CONSTRUCTION DRAWINGS FOR LOT 4, THE SHOPS FILING NO. 1 AT MERIDIAN RANCH

IMPROVEMENT PLANS

LOT 4, THE SHOPS AT MERIDIAN RANCH FILING NO. 1
SITE CONSTRUCTION DOCUMENTS
COVER SHEET

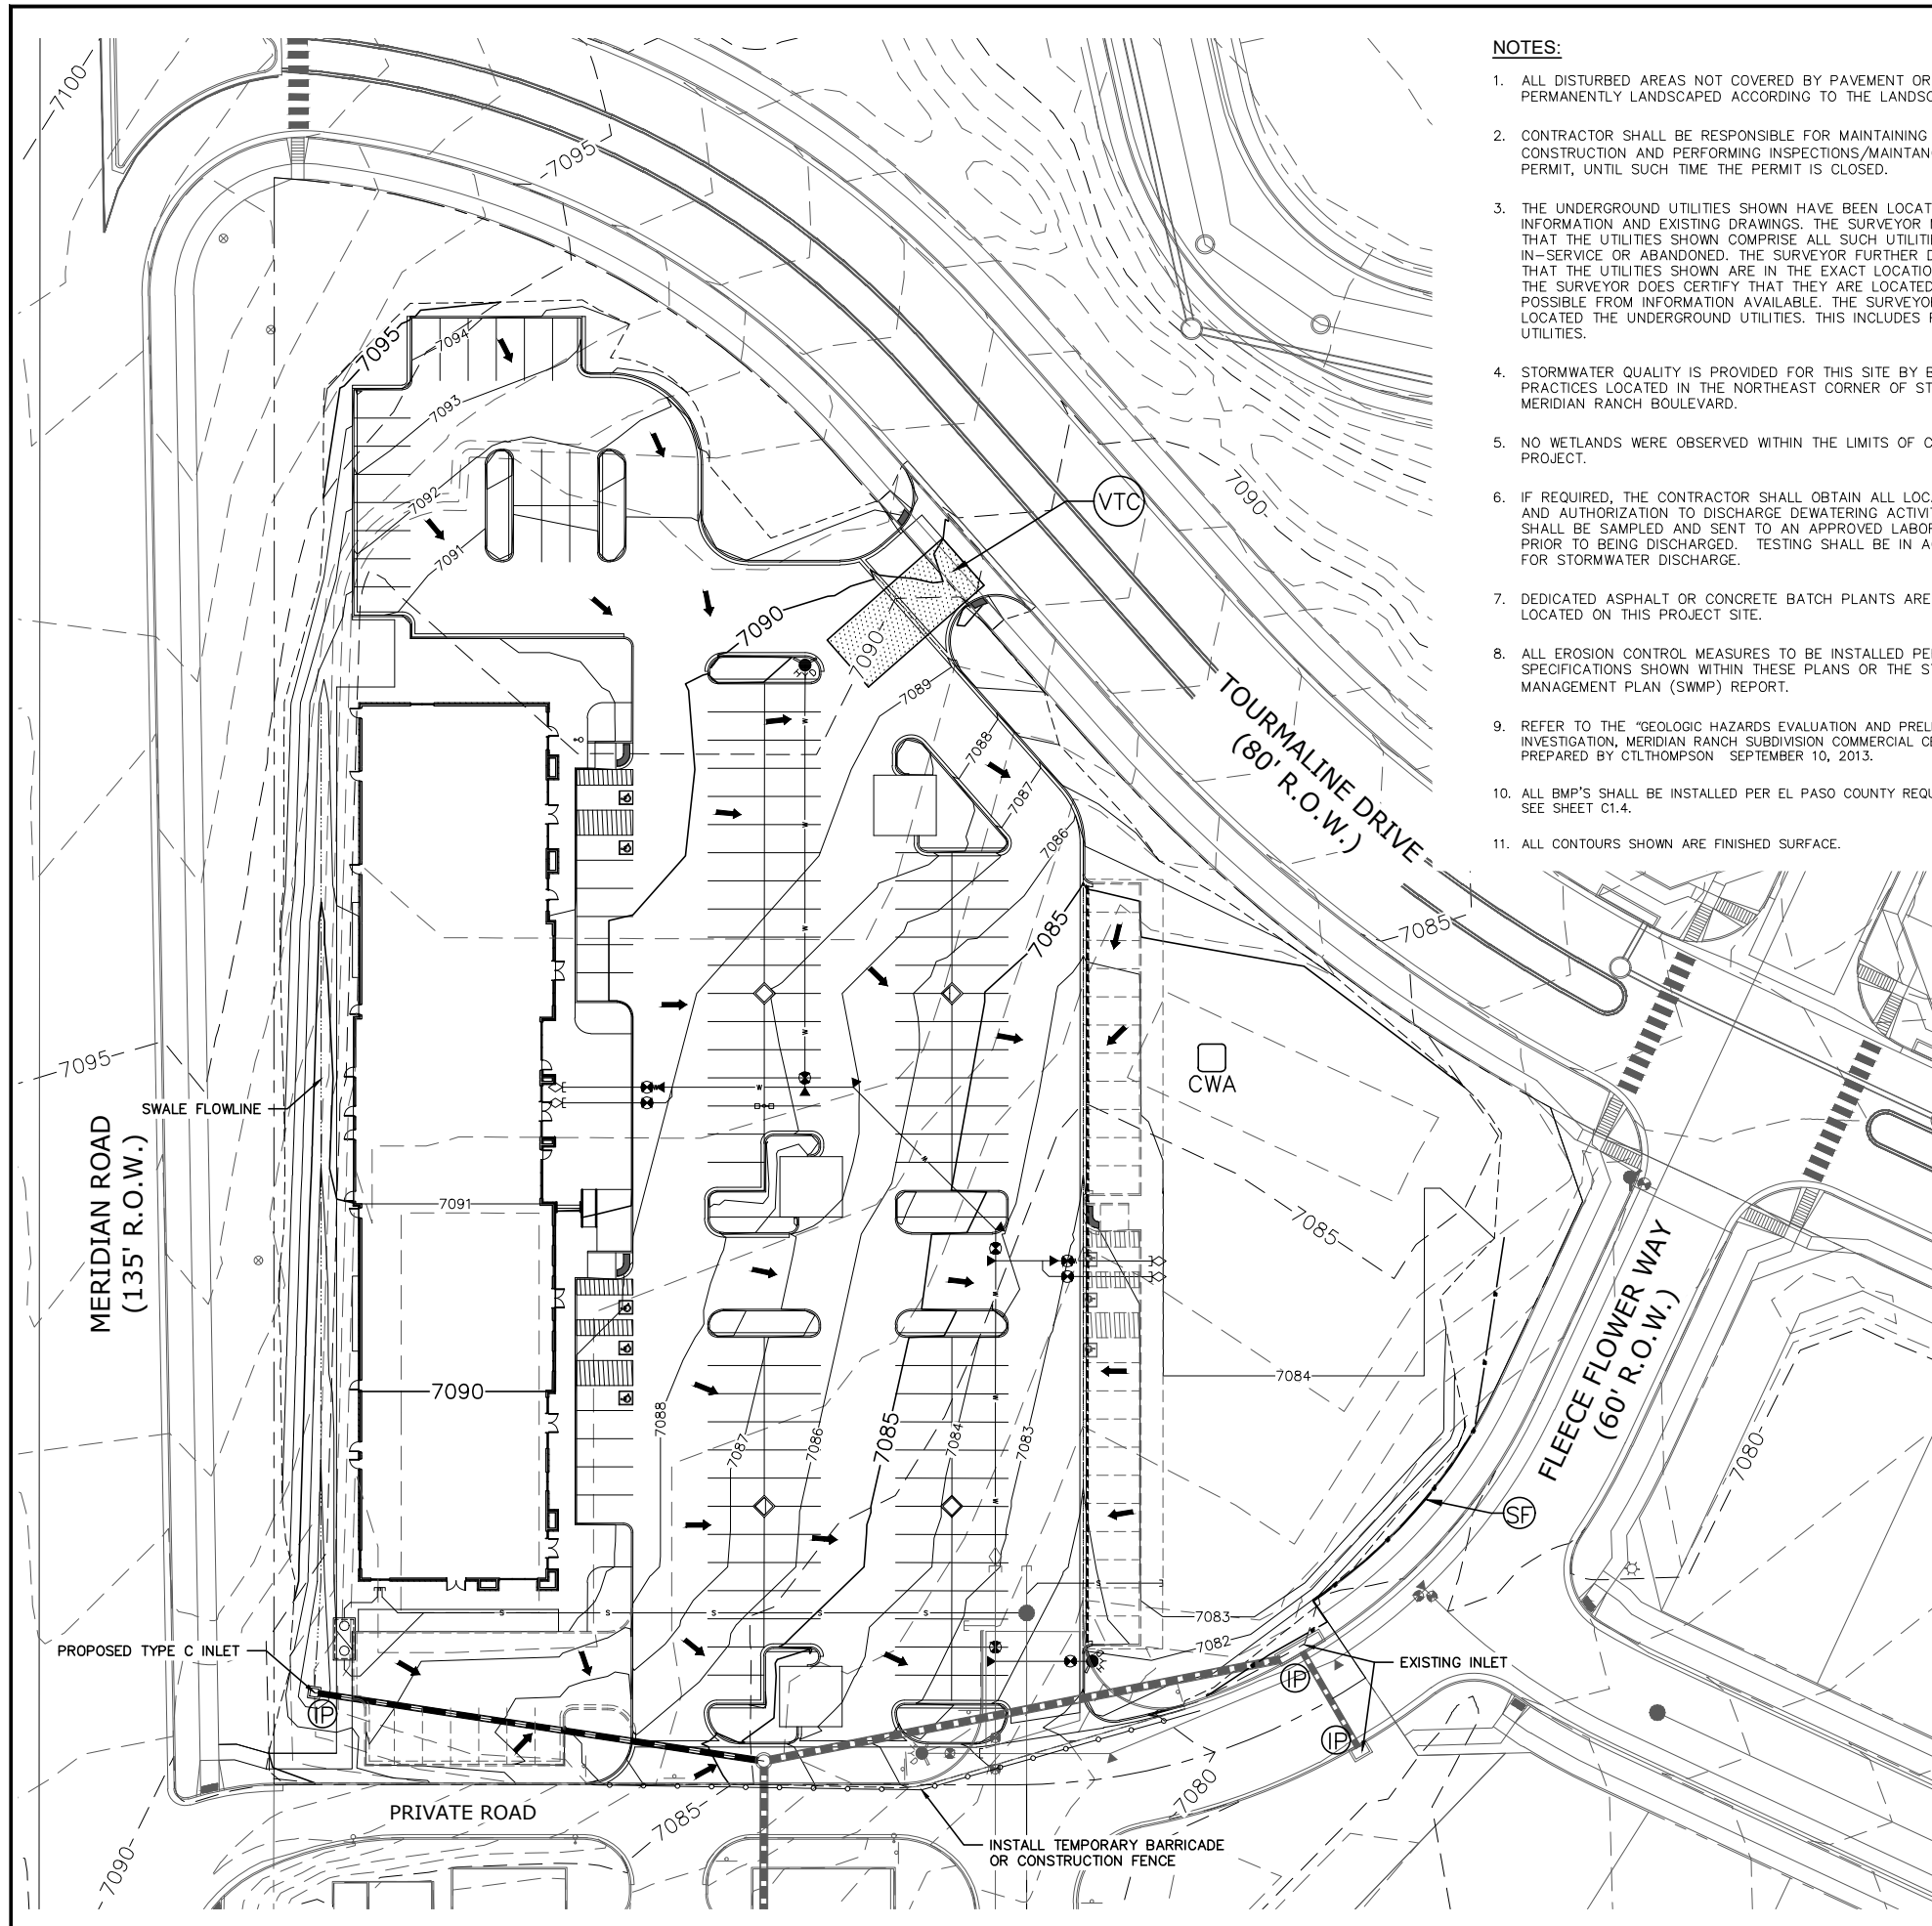
The orifice does not meet the outlet sizing requirements from DCM Vol. 2 Figure SB-2 Outlet Sizing. Update accordingly.

Identify the required volume for this pond. Based on this design, it does not appear that this pond meets the required volume. Update accordingly.
